From: Joanne Moxon [redacted]
Sent: 05 March 2014 11:28
To: Anita Gardner
Subject: RE: R/257/13 - Change of Use to Dog Day Care Centre - Unit 2, Phoenix Terrace, Artex Avenue, Rustington

From: Anita Gardner [redacted]
Sent: 05 March 2014 10:45
To: 'jo@pawsplaystay.co.uk'
Subject: R/257/13 - Change of Use to Dog Day Care Centre - Unit 2, Phoenix Terrace, Artex Avenue, Rustington

Proposed Ground Floor Plan 1:100  
Rev A  
Prepared for Arun District Council  
January 2014

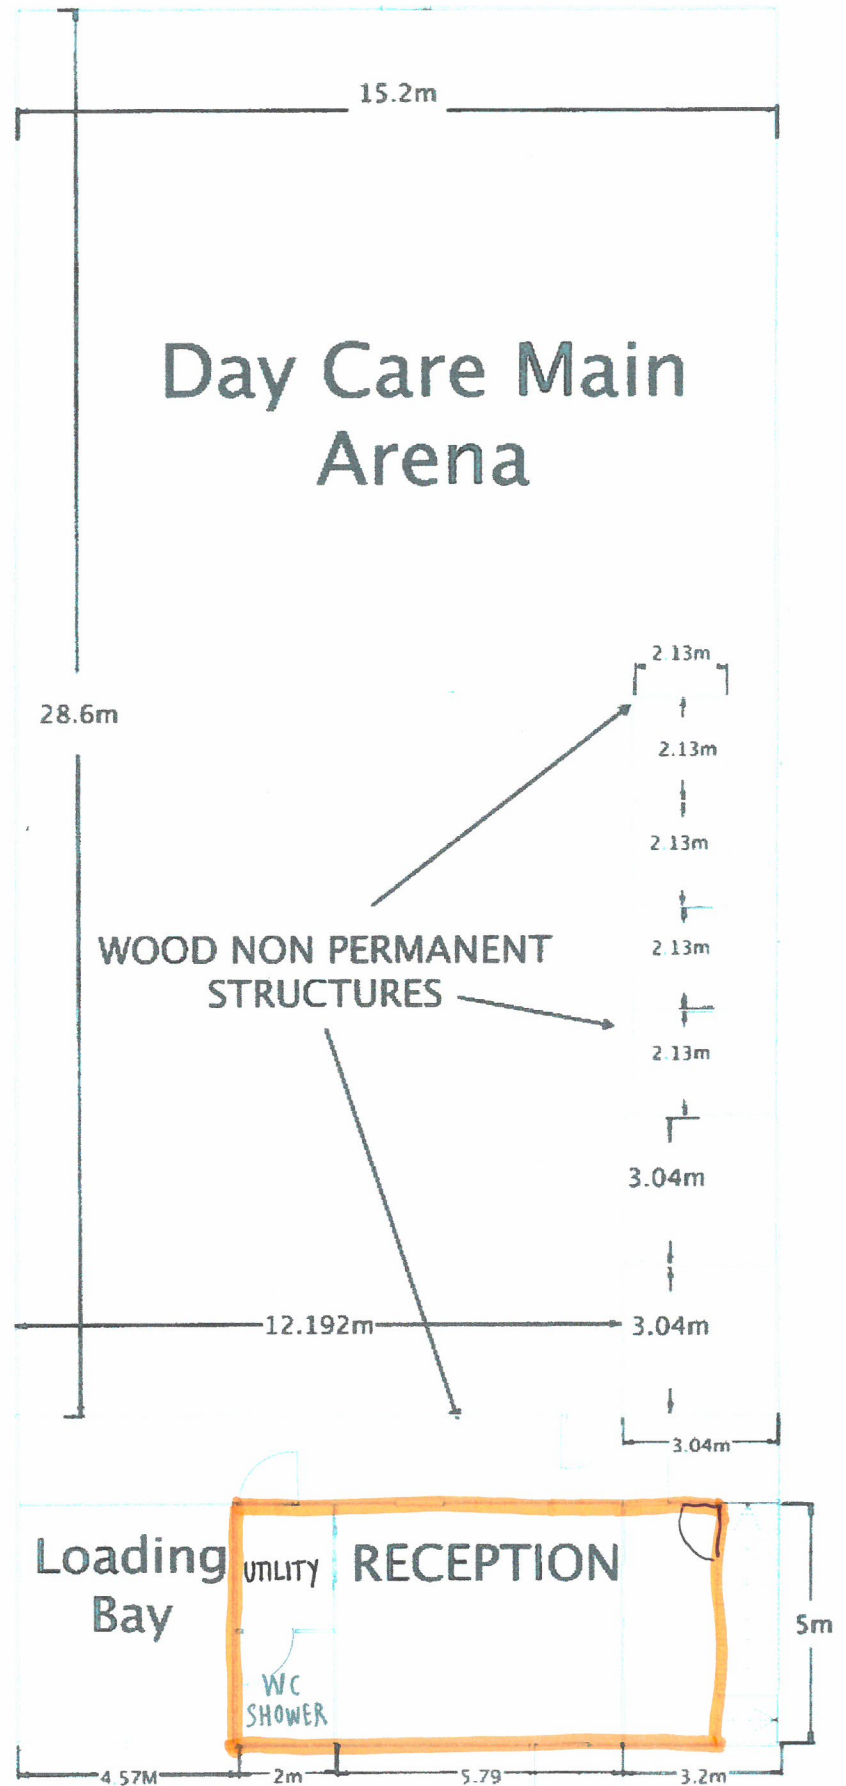
I am the case officer dealing with your planning application. I am in the process of writing up my report for the application. Having studied the forms and plans submitted there appear to be some discrepancies. Stairs are indicated on the ground floor layout plan and space above the reception area at first floor exists and is utilised. A first floor layout plan is therefore required to be submitted as part of the application. In addition Q18 of the form refers to a gross internal floor area of 5,000 square metres, but the ground floor plan area measures 35.4m x 15.2m totalling 5,380 and the area of the first floor also needs to be added to this.

Without prejudice, I would therefore appreciate, as a matter of urgency, receipt of a first floor plan and an amended figure in response to Q18.
